# ENG-CDR20005-R2-CD-Marksheffel-Redlines.pdf Markup Summary

SEPTEMBER 2  
CDR-20-005

STERLING RANCH - VOLLMER ROAD FILING 2 PLAN & PROFILE	SHEET 3 OF 11
JOB NO. 25188.01

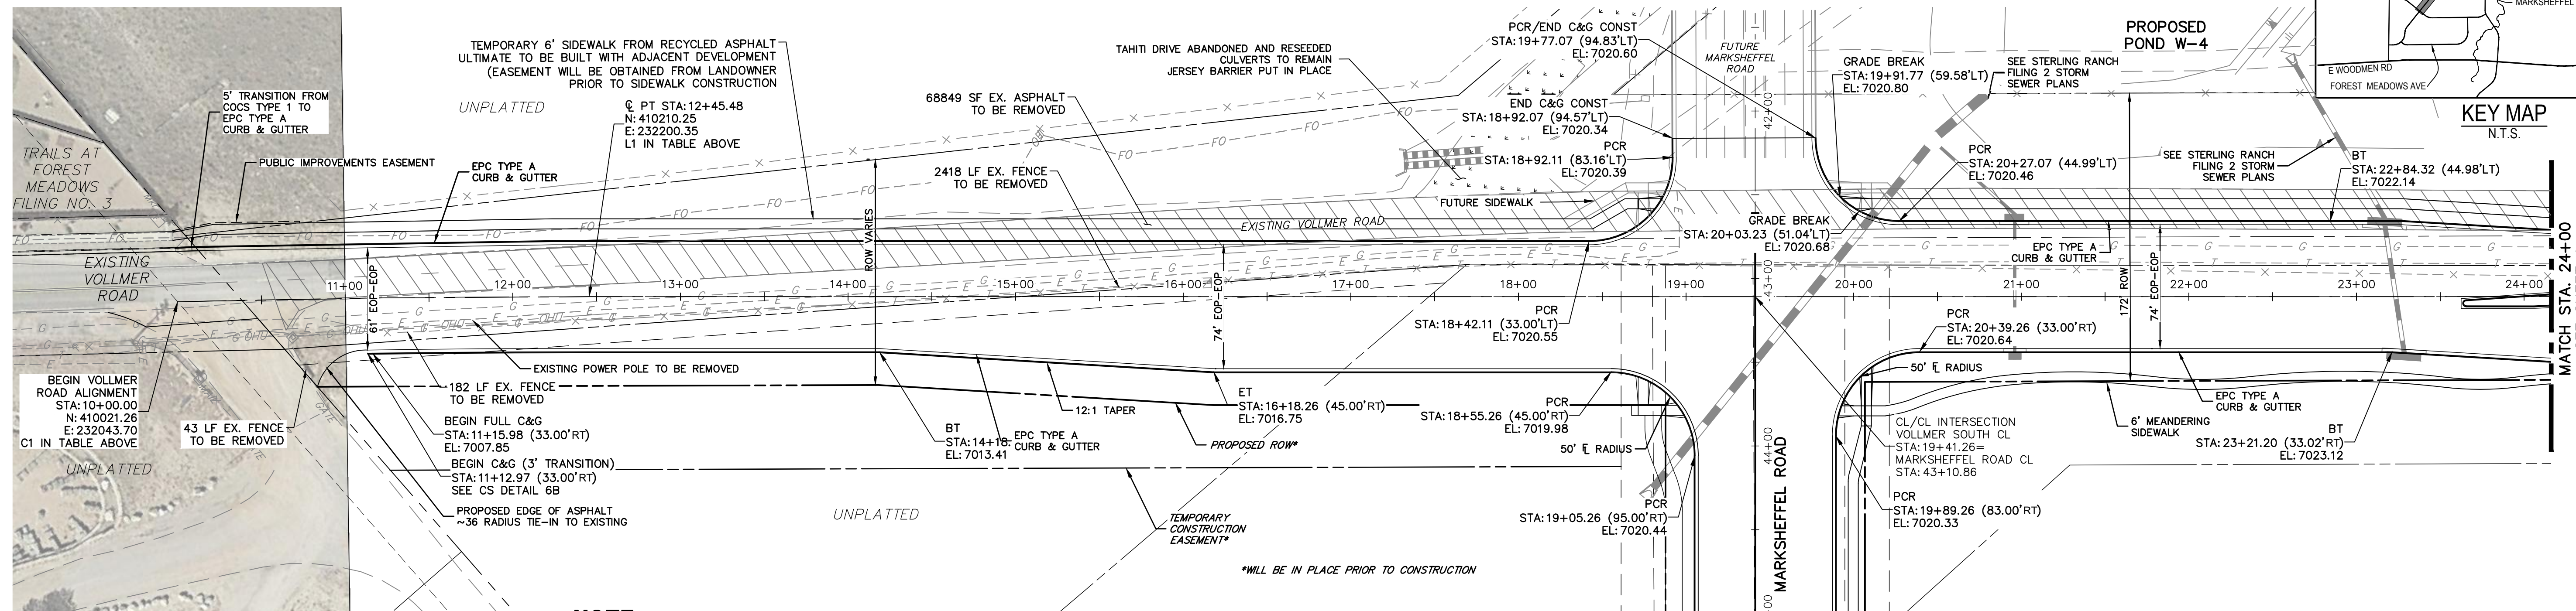
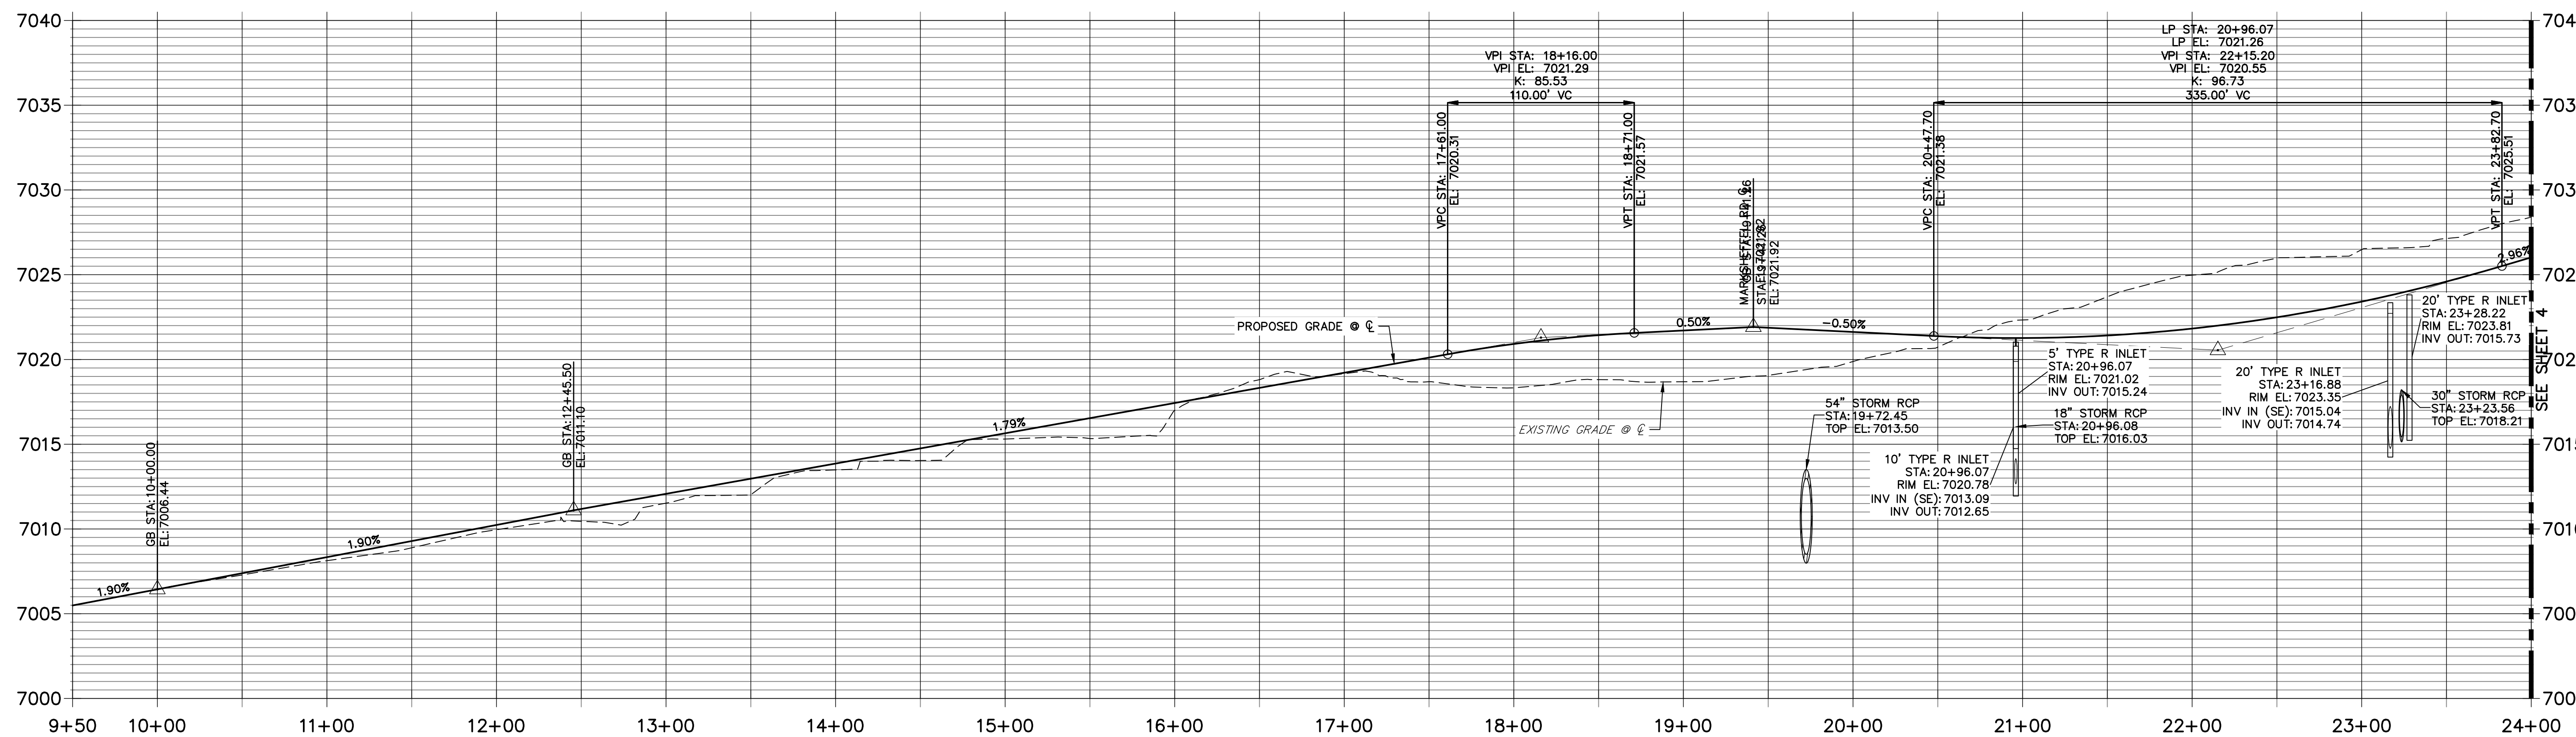
Per notations, Filing 2 storm drain construction needs to be approved and constructed prior to these plans.
